DEVIATION REVIEW AND DECISION FORM

**Deviation No. 1
REV 3-14-19**

Subdivision or Project Name: Rollin' Ridge

Section of ECM from Which Deviation is Sought: 2.3.2 Design Standards by Functional Classification

ENTRY DETAIL

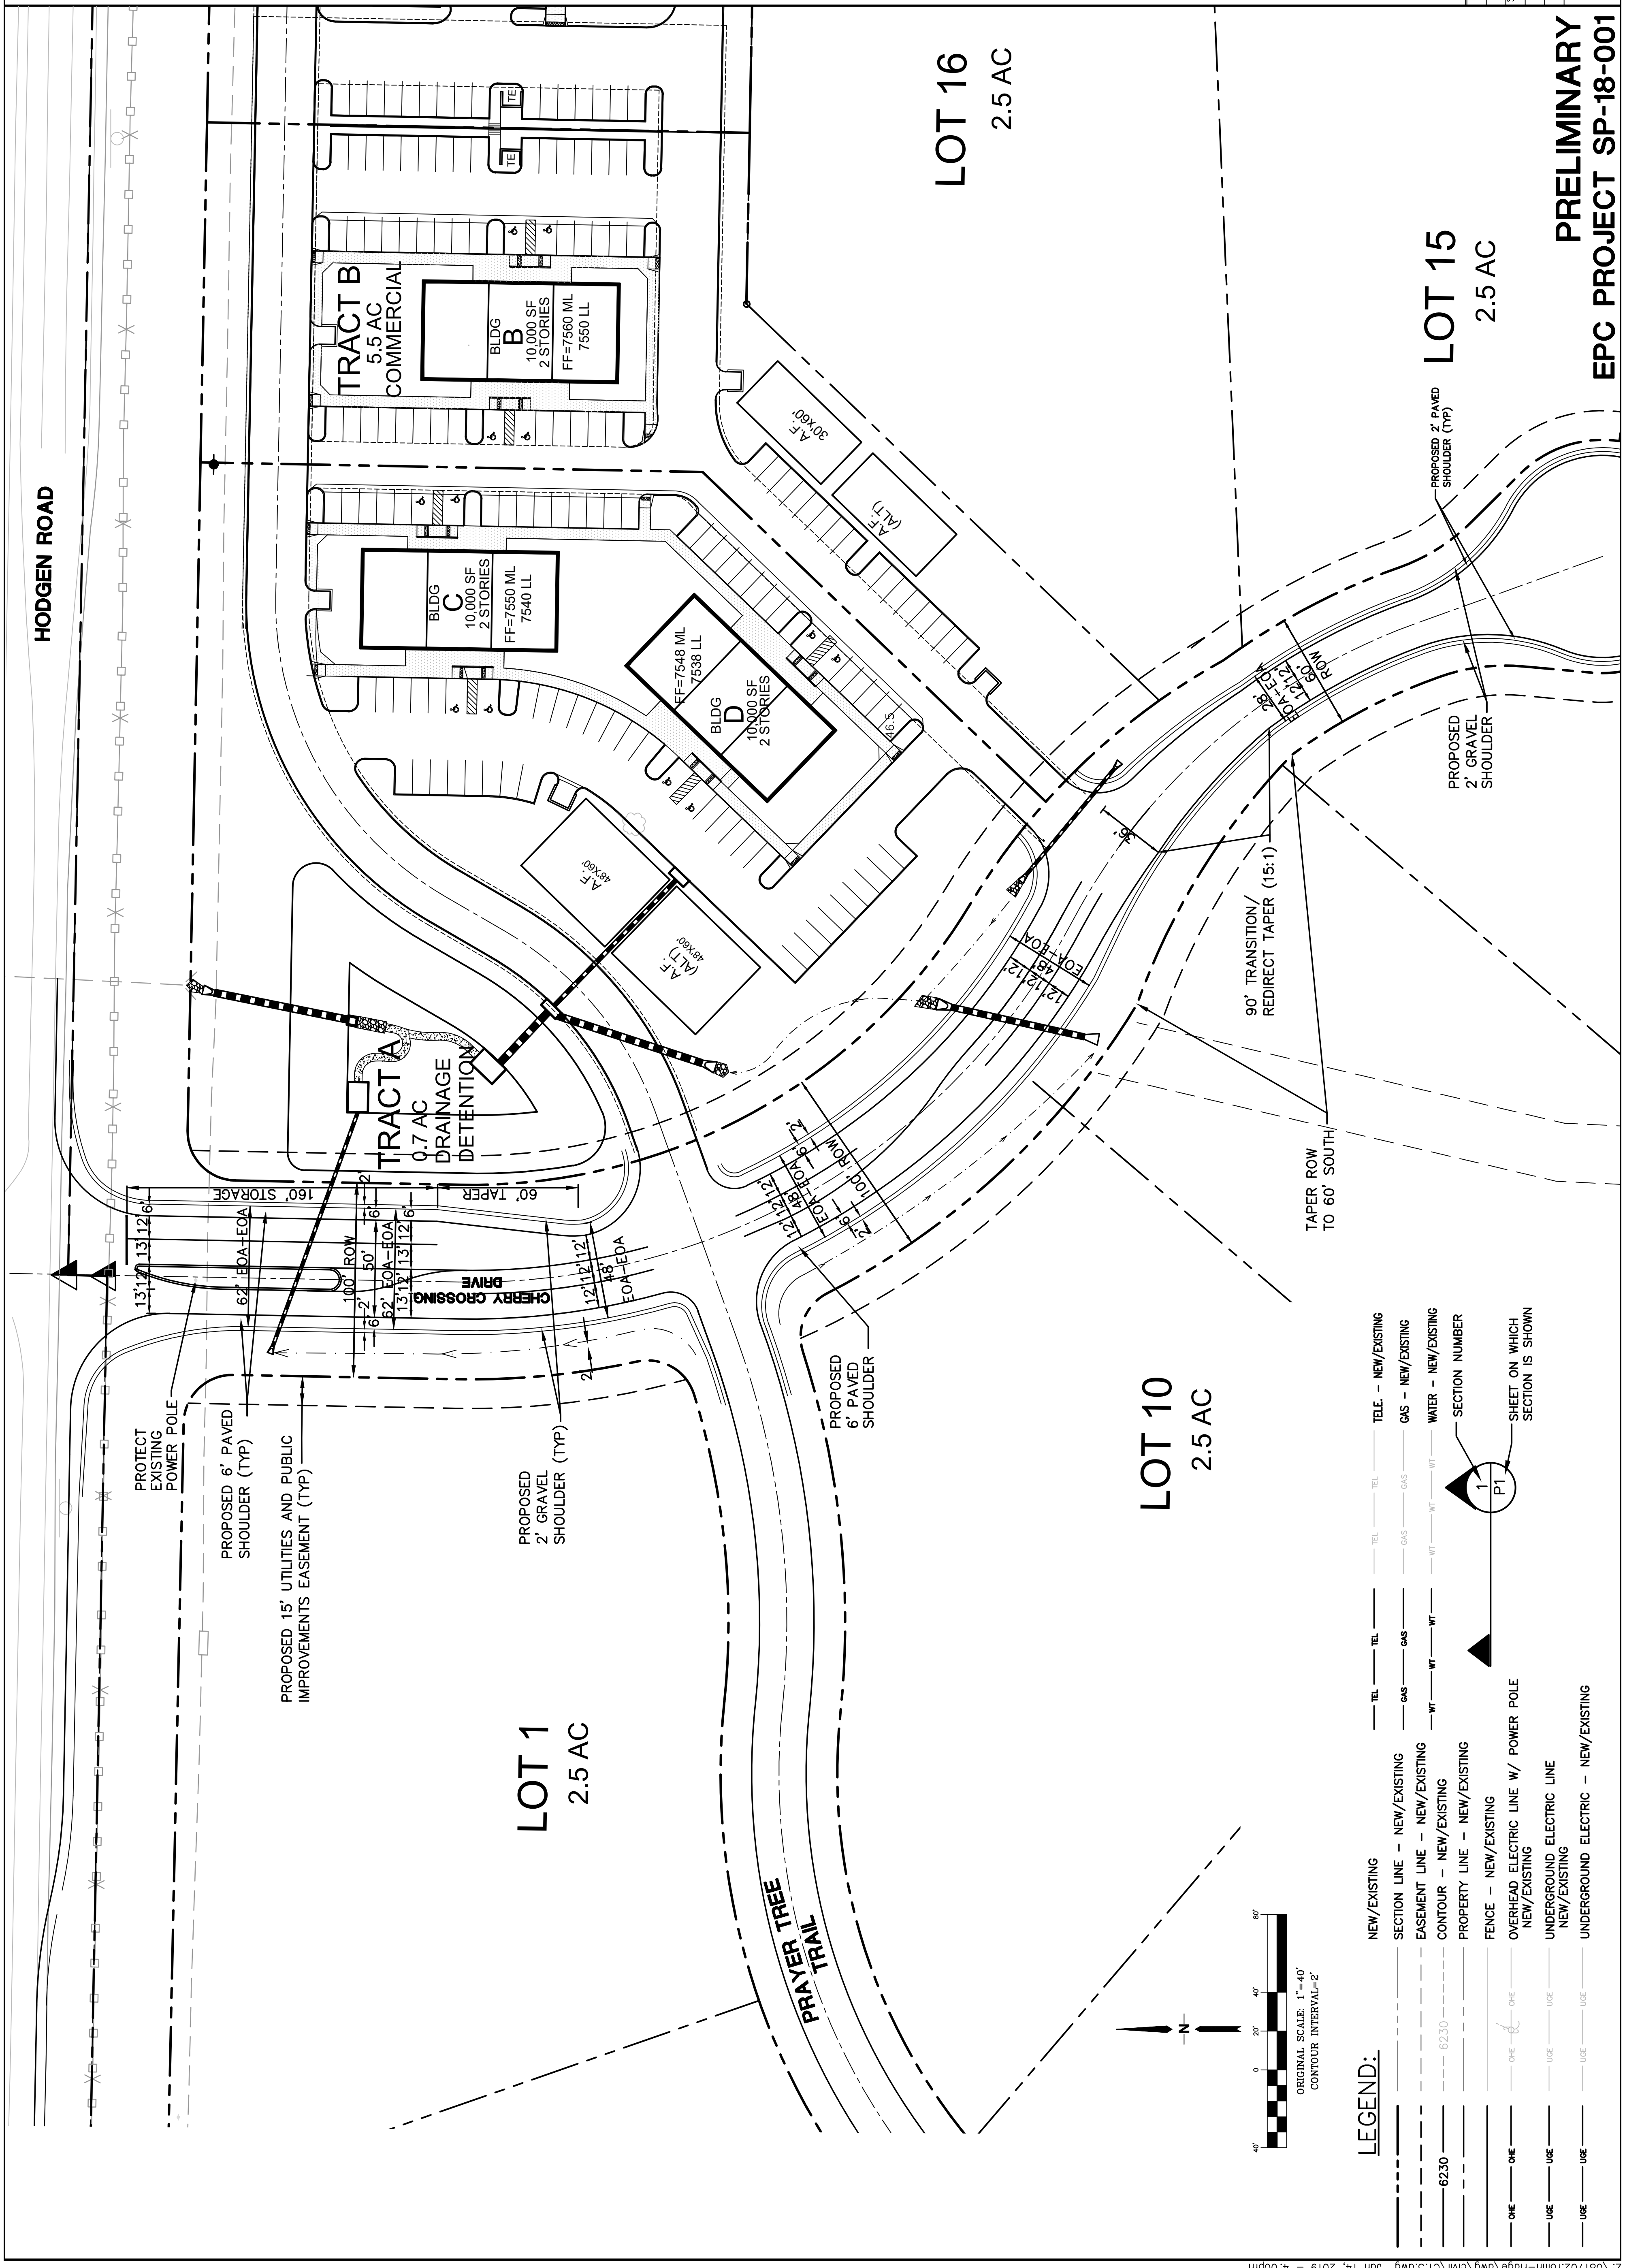
Proposed Nature and Extent of Deviation: This deviation request is to allow a Rural Minor Arterial with the following modified design elements for the proposed Cherry Crossing Drive south of Hodgen Road and north of the south commercial access: Allow a design speed of 30 mph and a posted speed of 30 mph; a minimum centerline radius of 350'; allow a six foot outside paved shoulder instead of an eight foot paved shoulder; and intersection spacing of 360' instead of one-quarter mile (Note: Also see separate Deviation No. 2)(Please refer to the attached exhibit); permit a commercial access point - otherwise there would be "No Access Permitted" per Table 2-4. Please refer to the "Entry Detail" exhibit included in the TIS report.

Proposed Nature and Extent of Deviation: This deviation request is to allow a Rural Minor Arterial with the following modified design elements for the proposed Cherry Crossing Drive south of Hodgen Road and north of the south commercial access: Allow a design speed of 30 mph and a posted speed of 30 mph; a minimum centerline radius of 350'; allow a six foot outside paved shoulder instead of an eight foot paved shoulder; and intersection spacing of 360' instead of one-quarter mile (Note: Also see separate Deviation No. 2)(Please refer to the attached exhibit); permit a commercial access point - otherwise there would be "No Access Permitted" per Table 2-4. Please refer to the "Entry Detail" exhibit included in the TIS report.

Approximate Scale
Scale: 1" = 360'

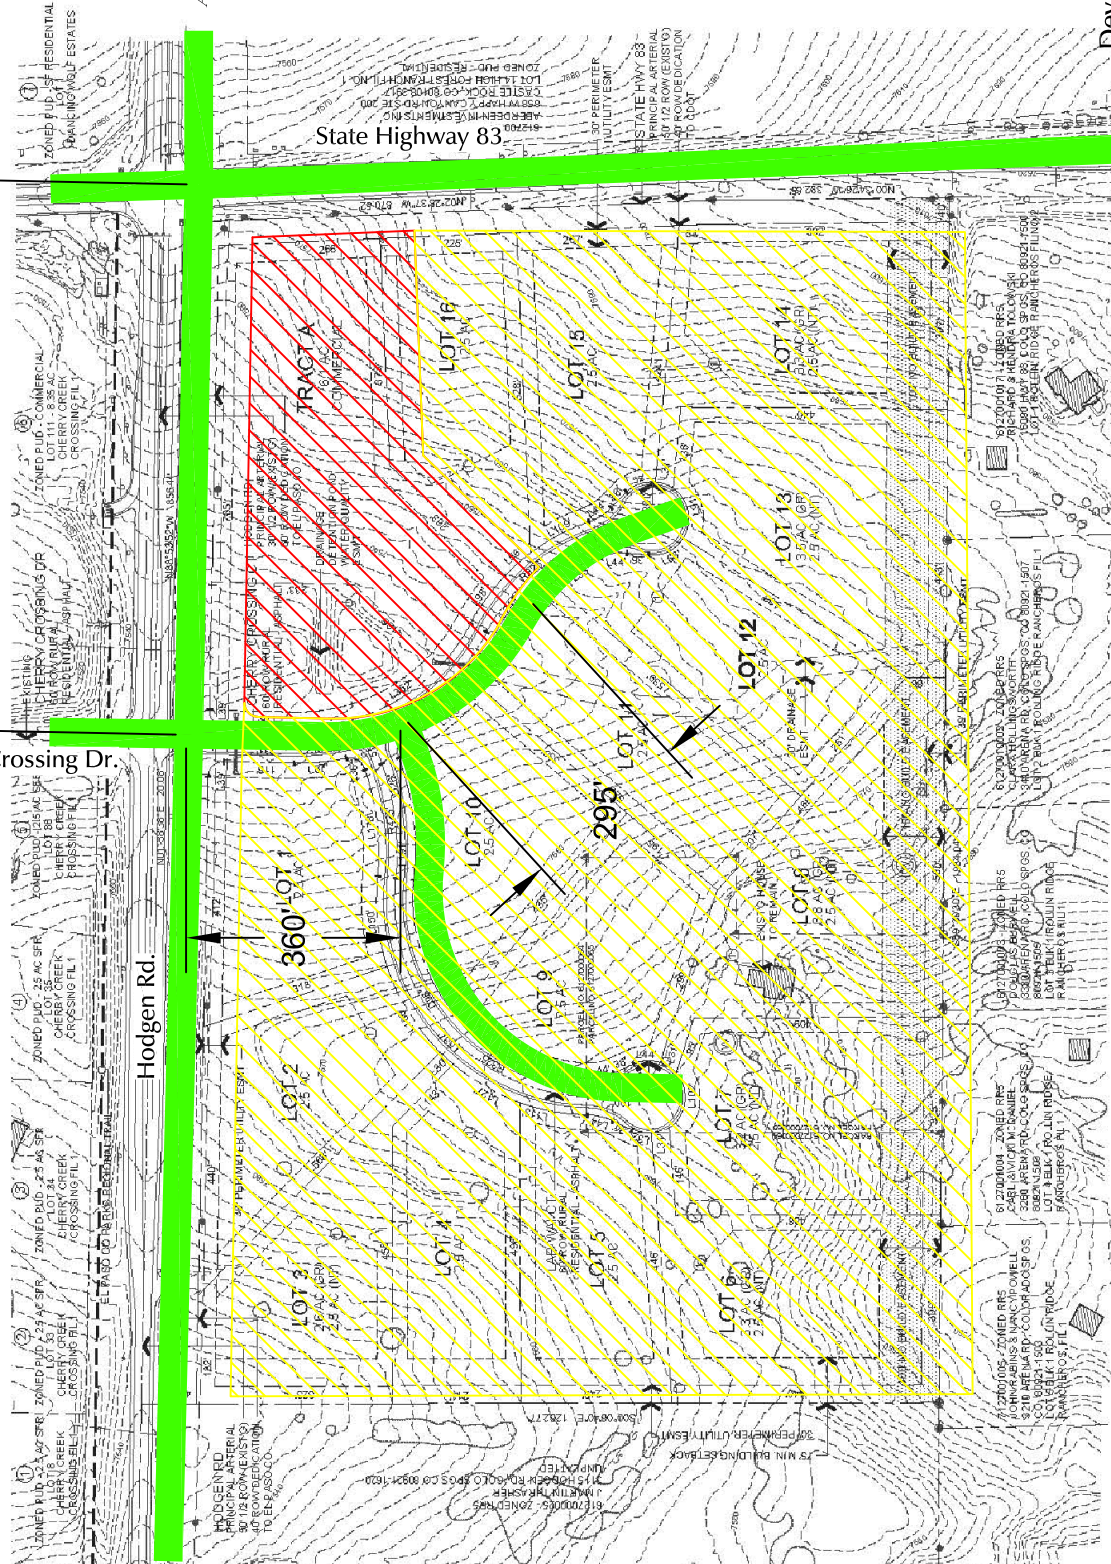
Intersection spacing is not part of this deviation. This exhibit is not necessary for this deviation request.
